**Consultation Response from KC,  
Trees**

**2020/94184 Stonecroft, Daisy Lea Lane, Lindley, Huddersfield, HD3 3LL**

**Erection of car port (Within a Conservation Area)**

**Date Responded: 04/02/21**

Drawing Number: **846 03 SK-01**

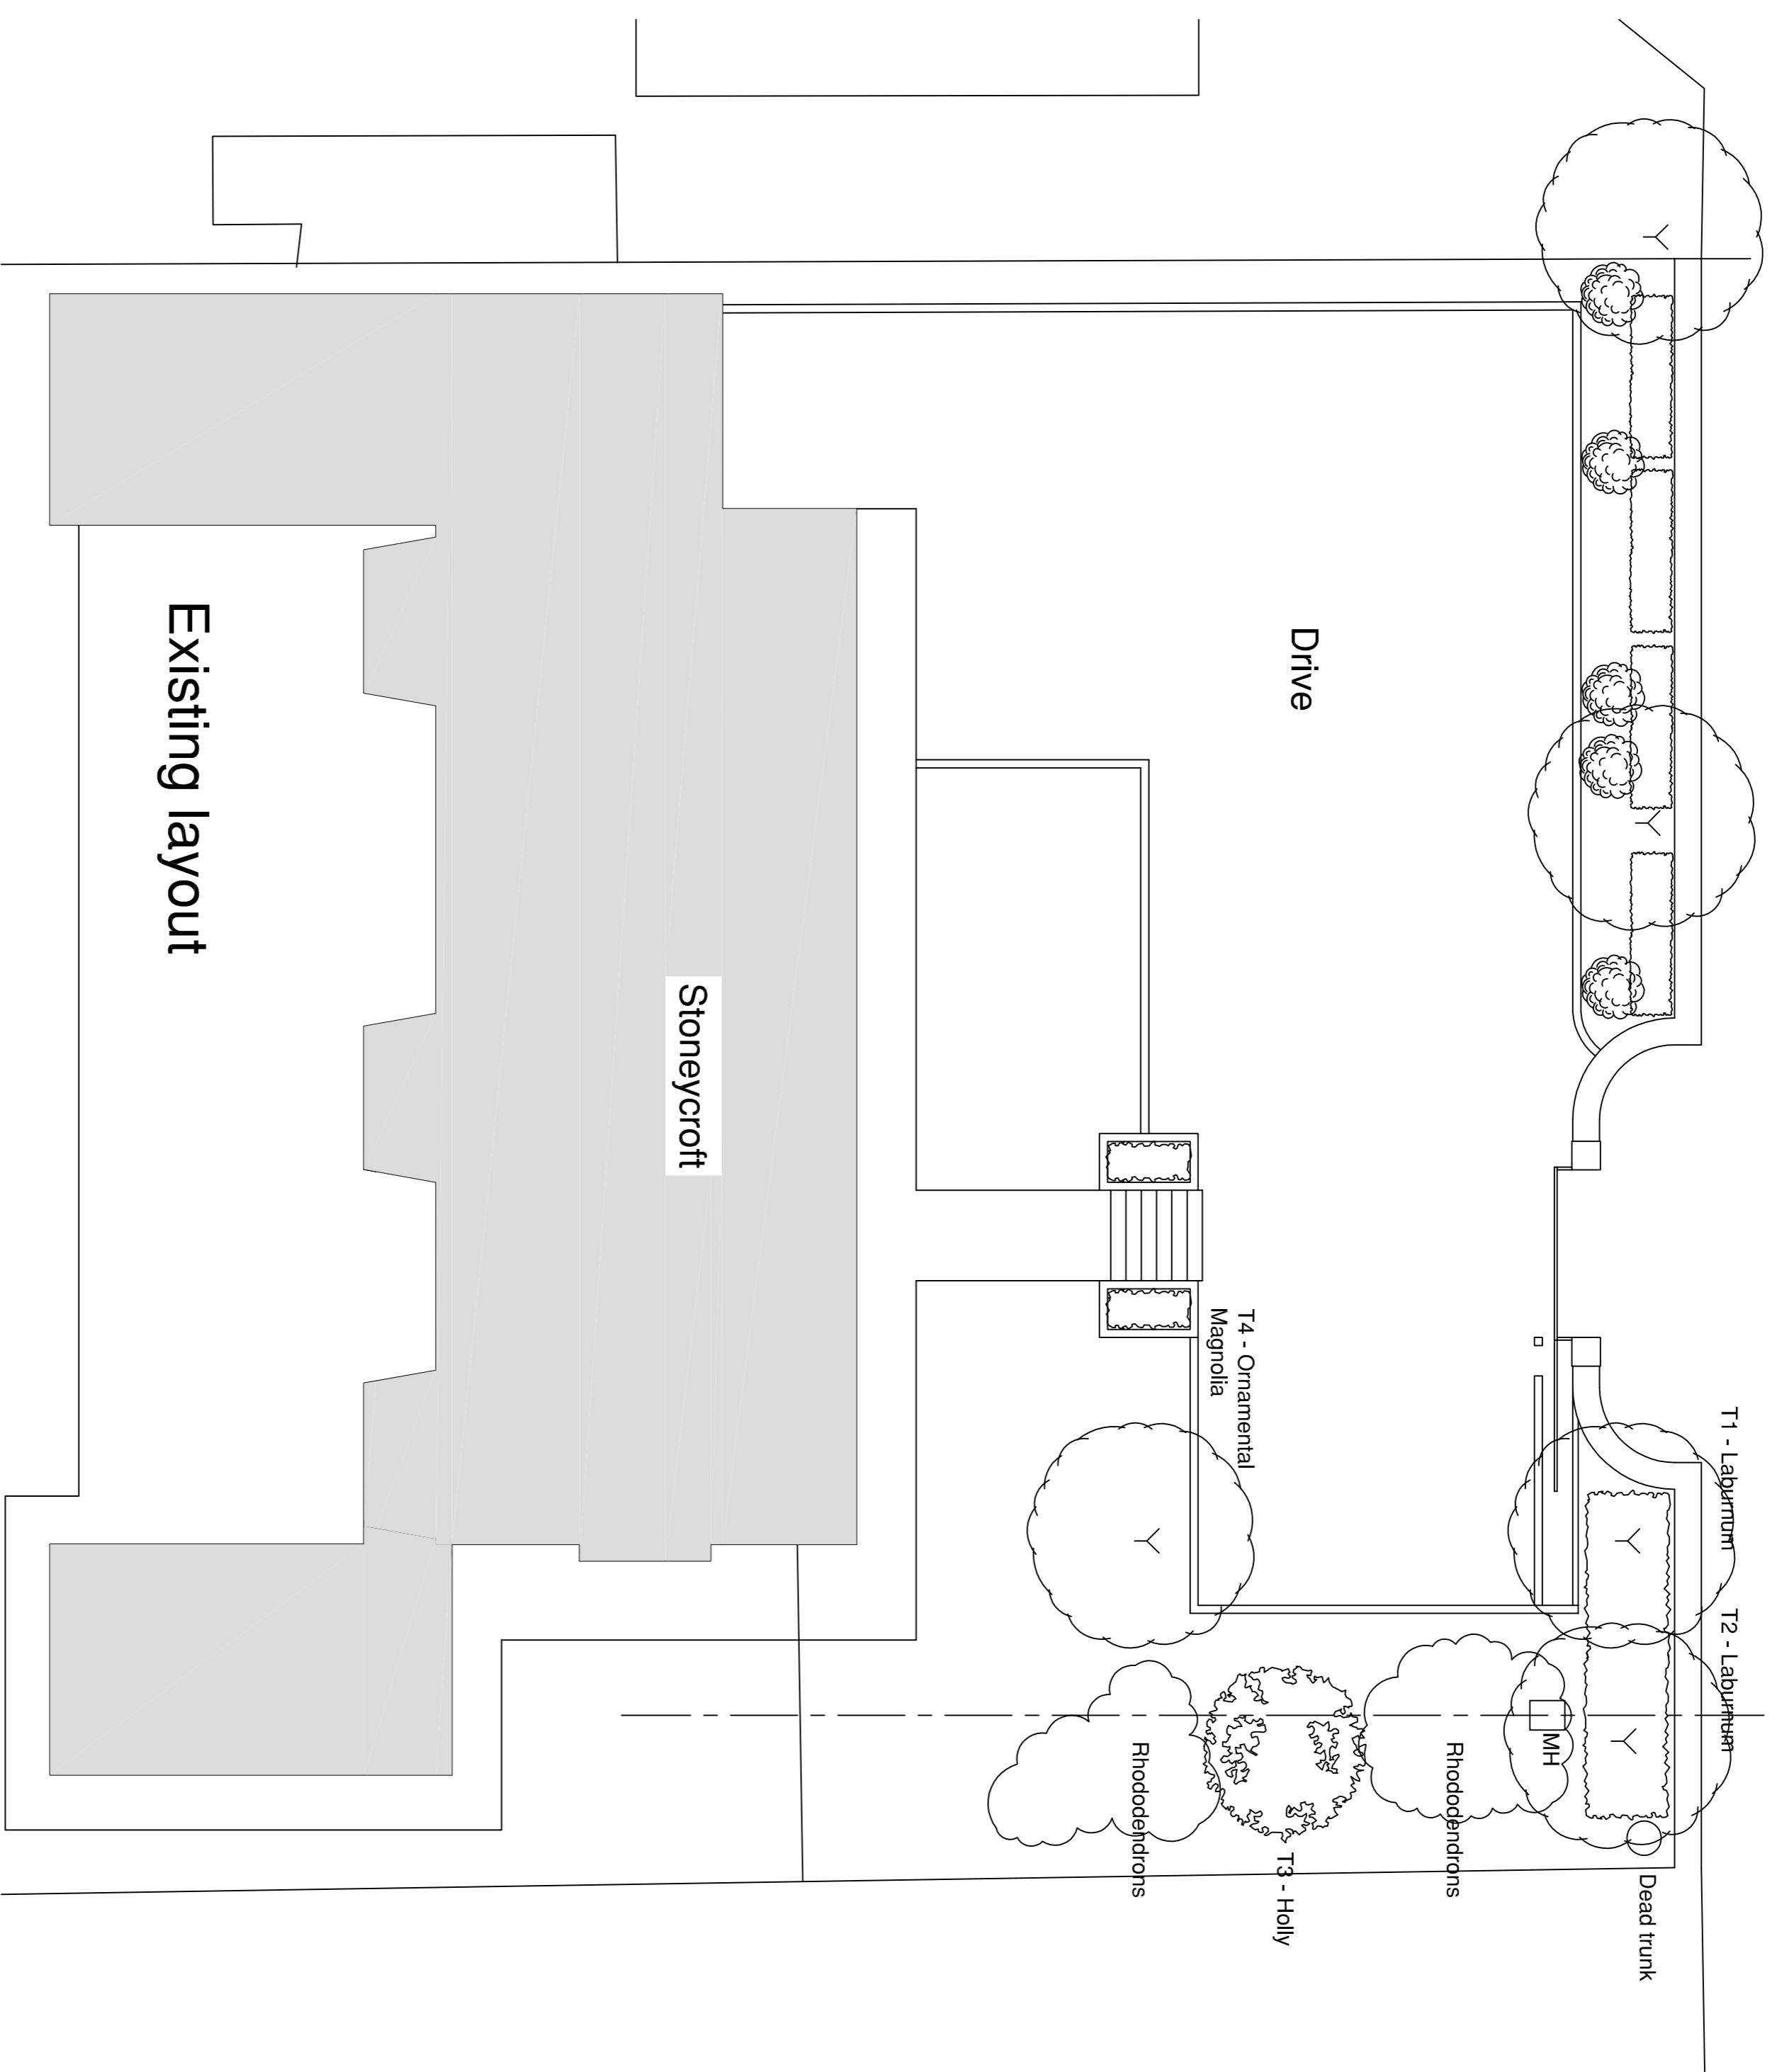
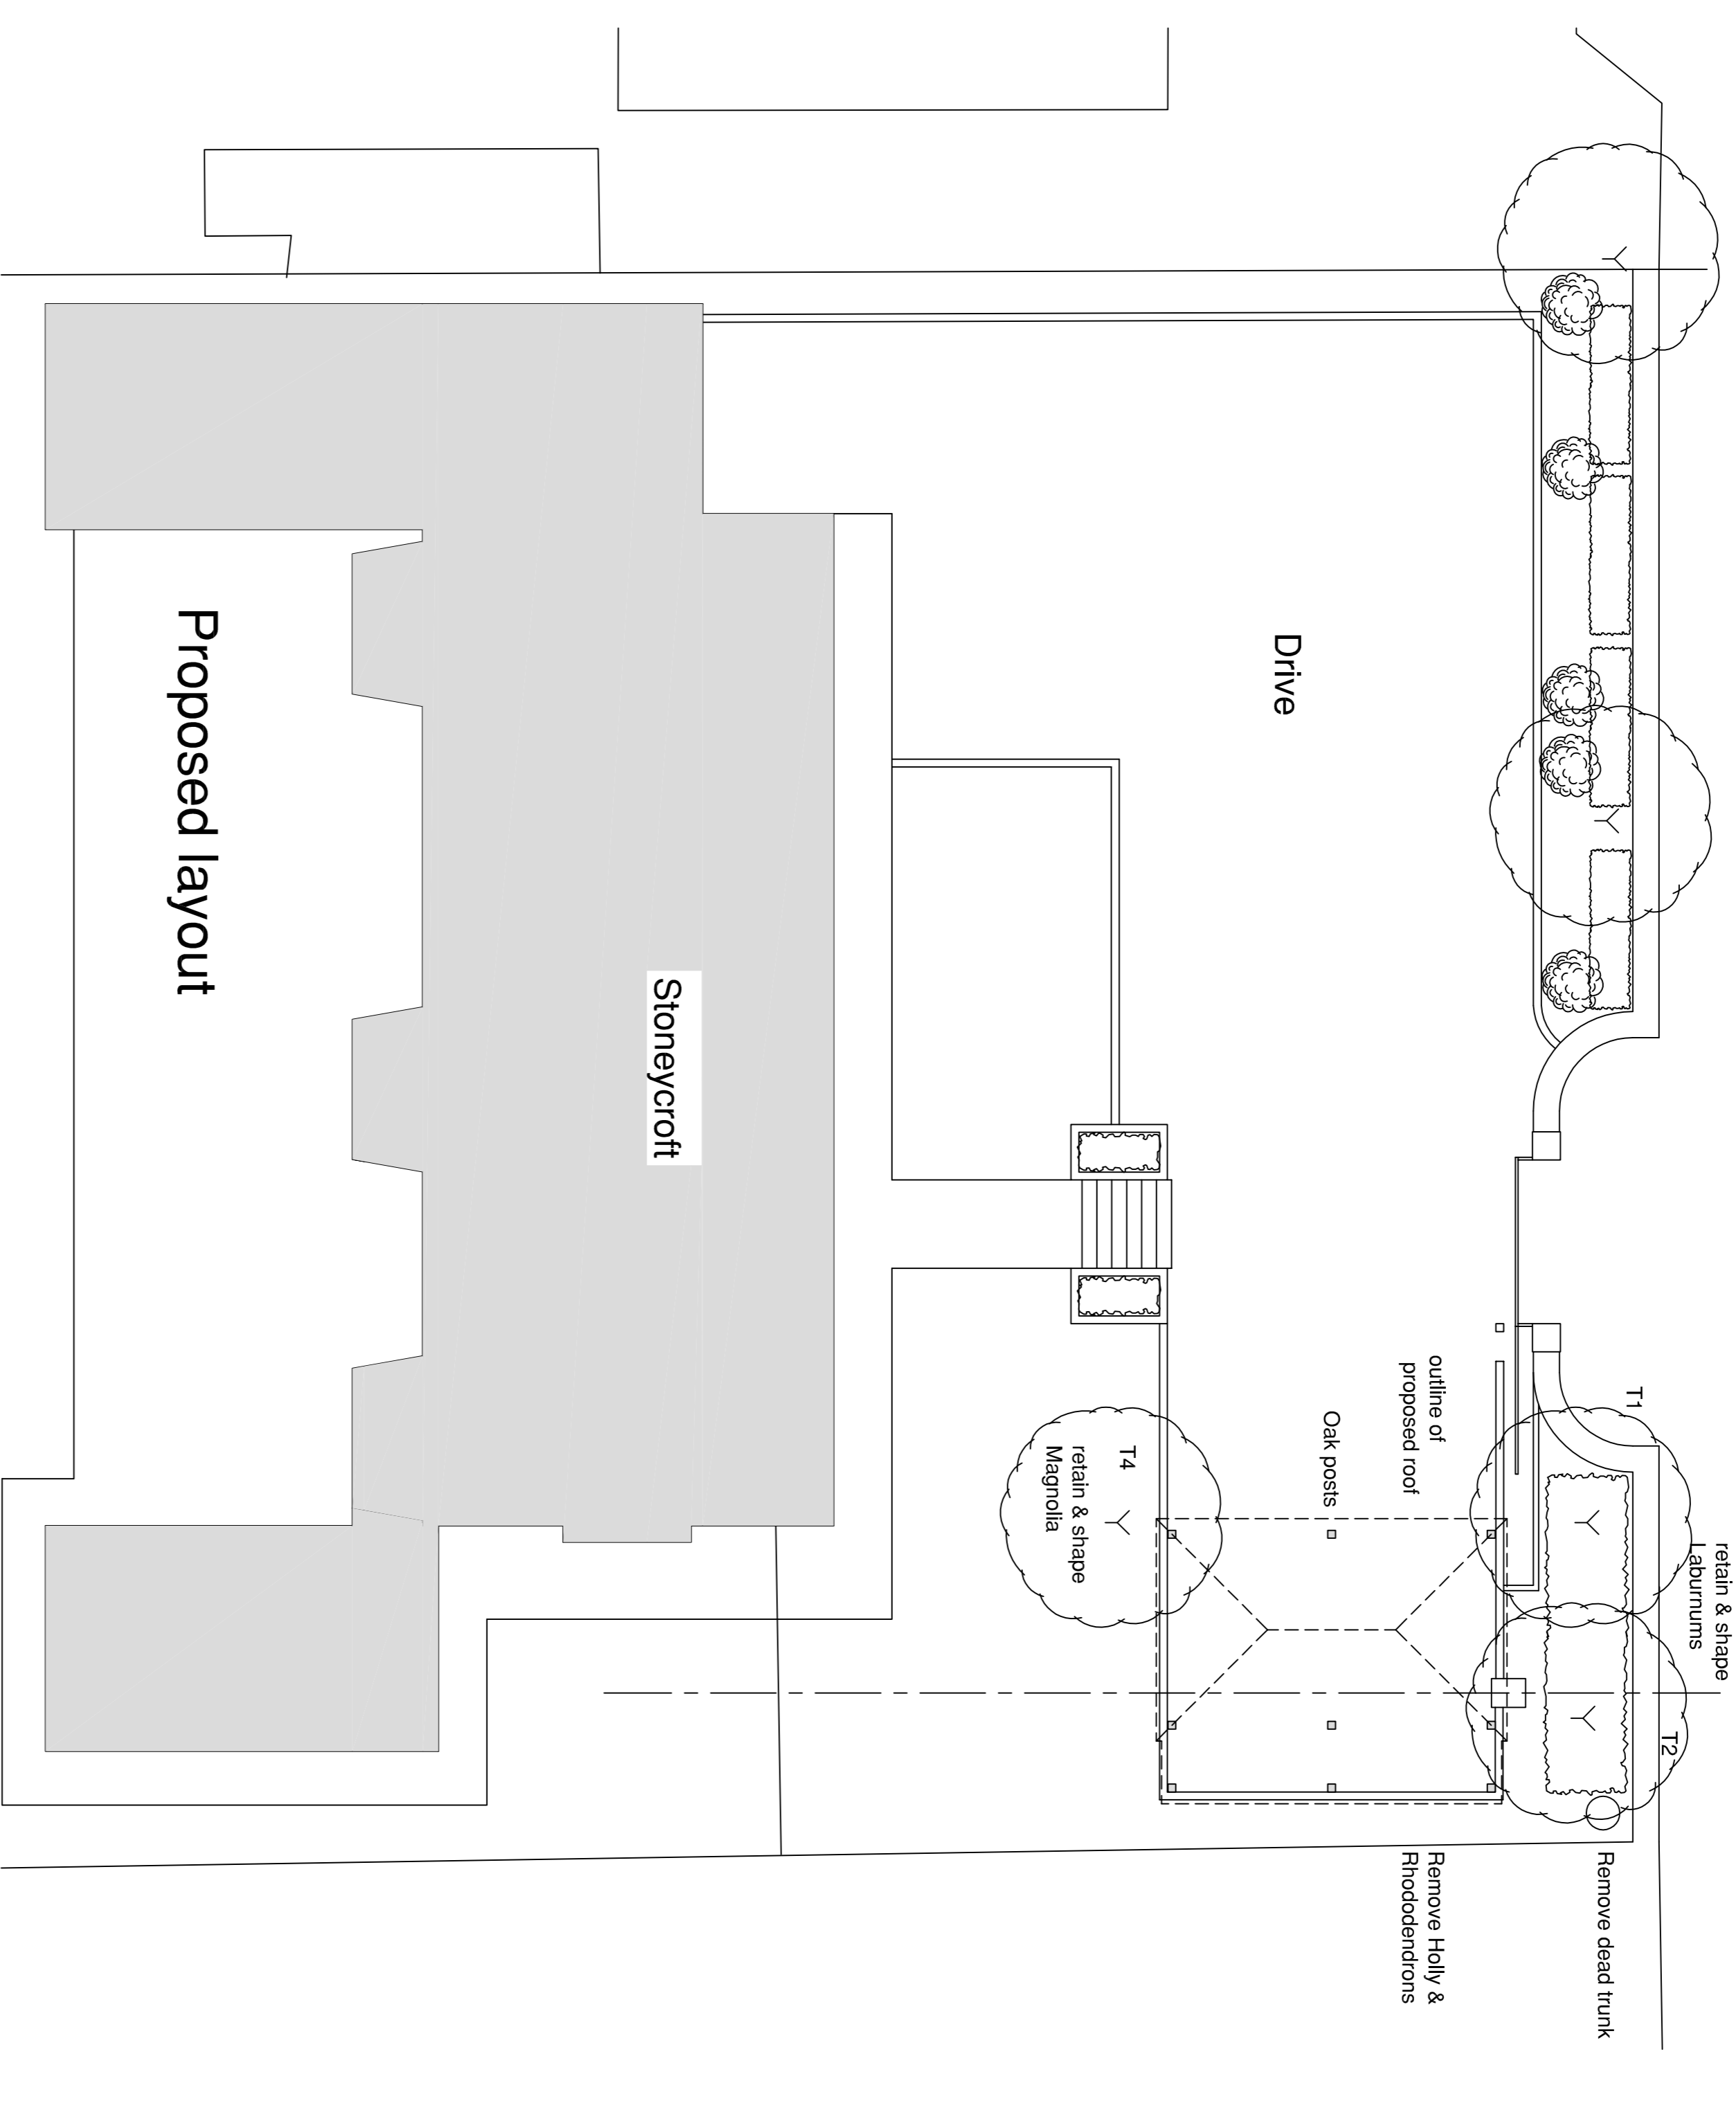
The property is within the Edgerton Conservation Area which protects all trees above a diameter of 75mm, when measured at 1.5m above ground level. The proposed car port would have only minimal impact on the roots of the adjacent laburnum trees and require the removal of garden shrubs of little consequence to the character of the conservation area. I would therefore have no objection to the proposals.
